Response to Submissions – SSD 6078

Oakdale Central – Horsley Park

Construction of Warehouse and Distribution Facilities - Lots 1C, 2B and 3

RE: Responses to EIS Addendum - SSD 6078

Title
TYPICAL
SECTIONS

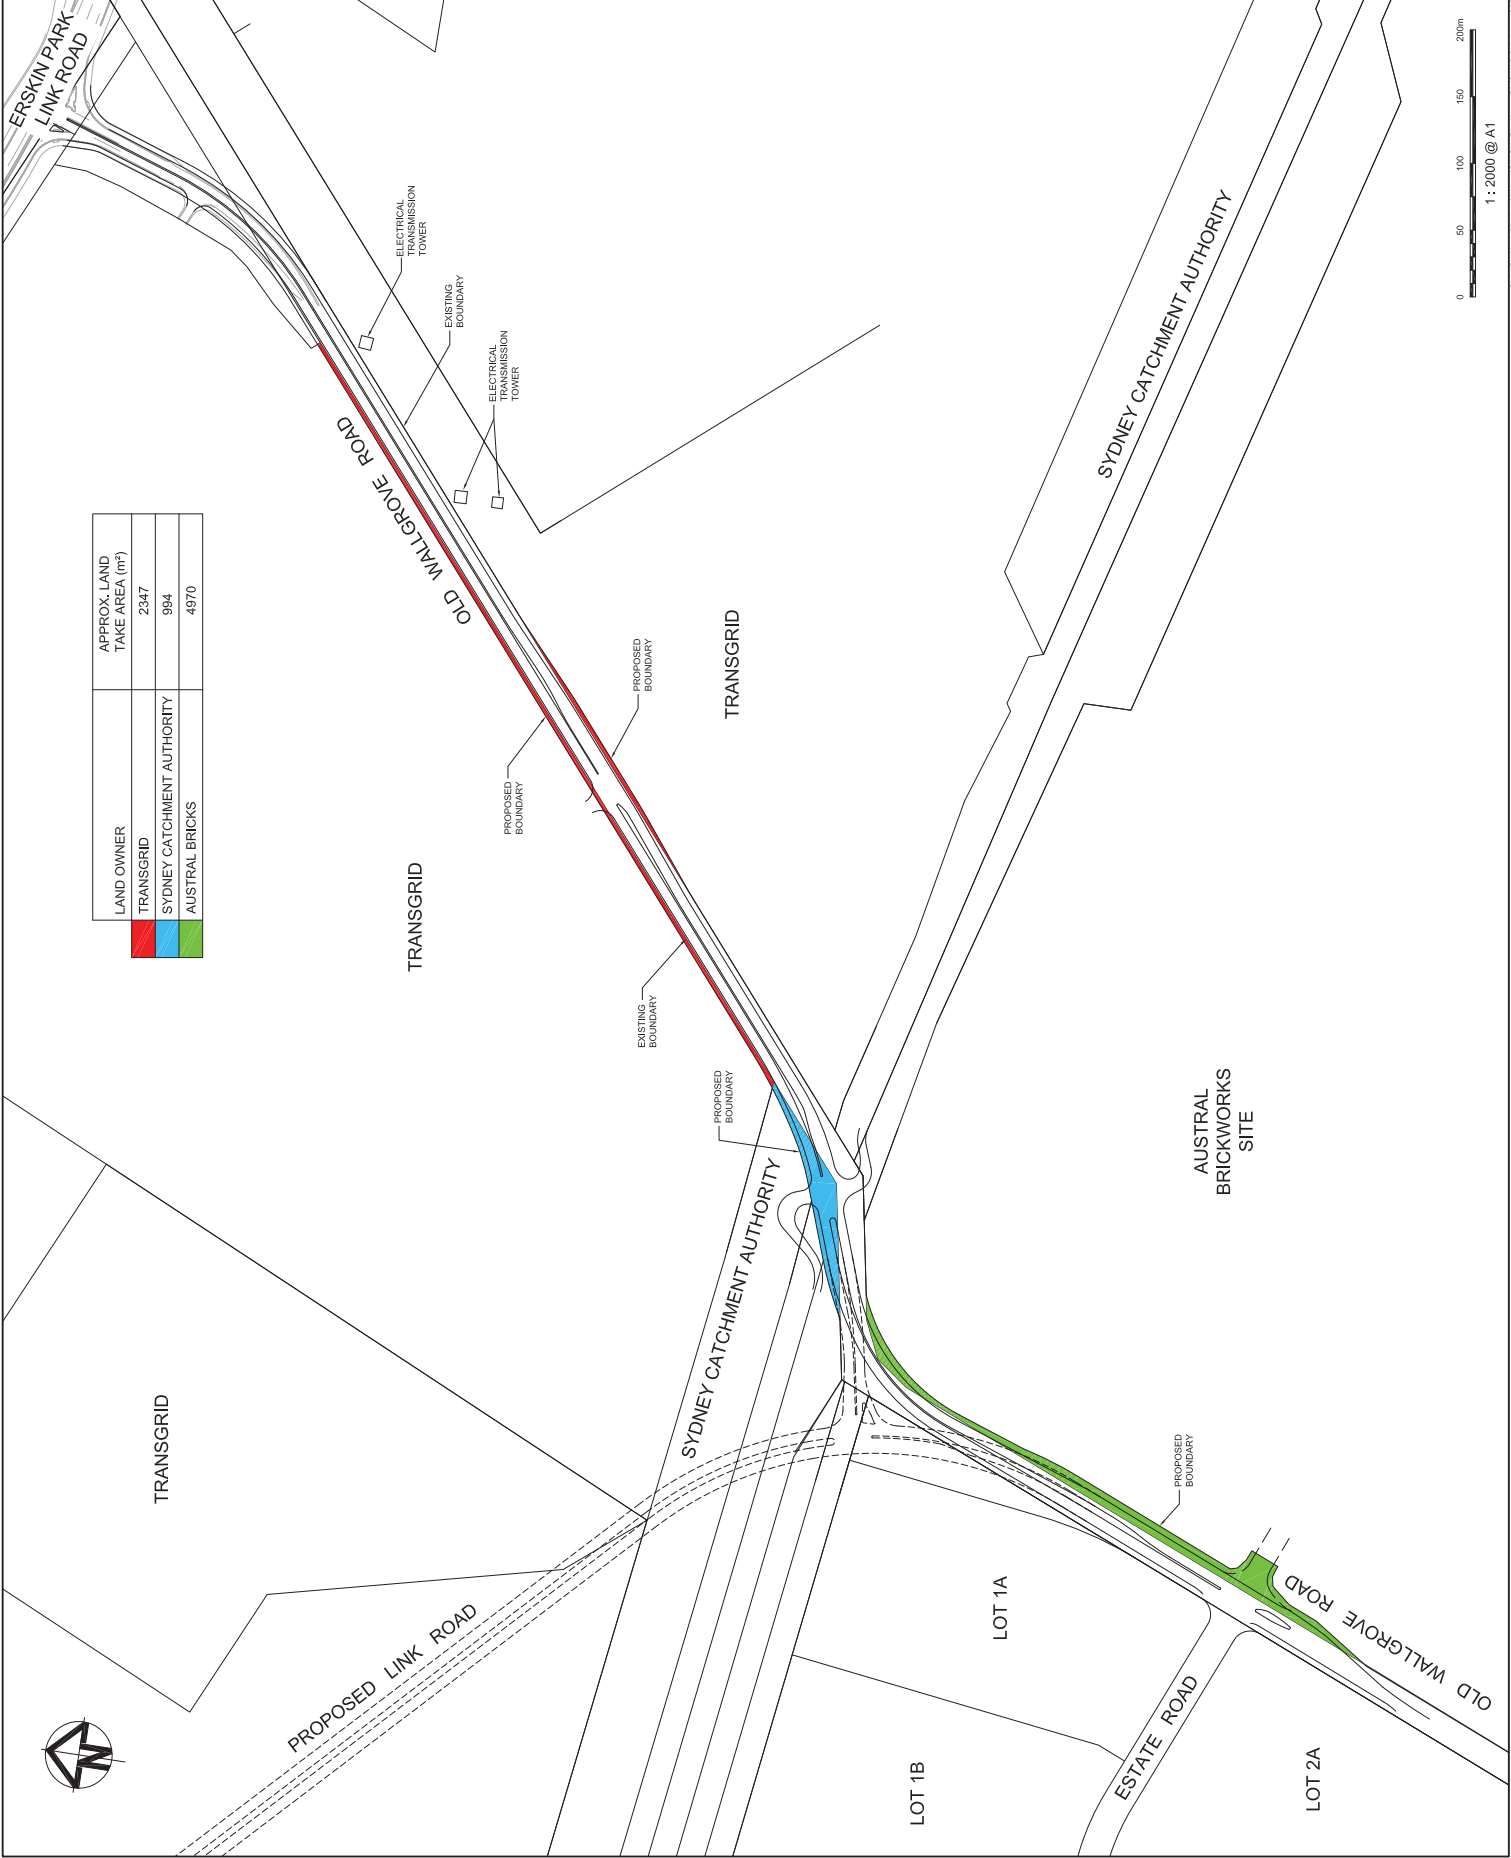
Nominated batter slopes do not comply with Council's engineering guide for development. On the basis that Council will be responsible for maintenance, compliance with EGFD is required.

Blacktown City Council EGFD states desirable max batter slope for roads shall be 1(V):5(H). Absolute max 1(V):4(H). The batter slopes shown in the concept design have been based on the Austroads/RMS design guidelines. The batter slopes adopted will be assessed further during detailed design through consultation with Council and based on the geotechnical investigation for the site.
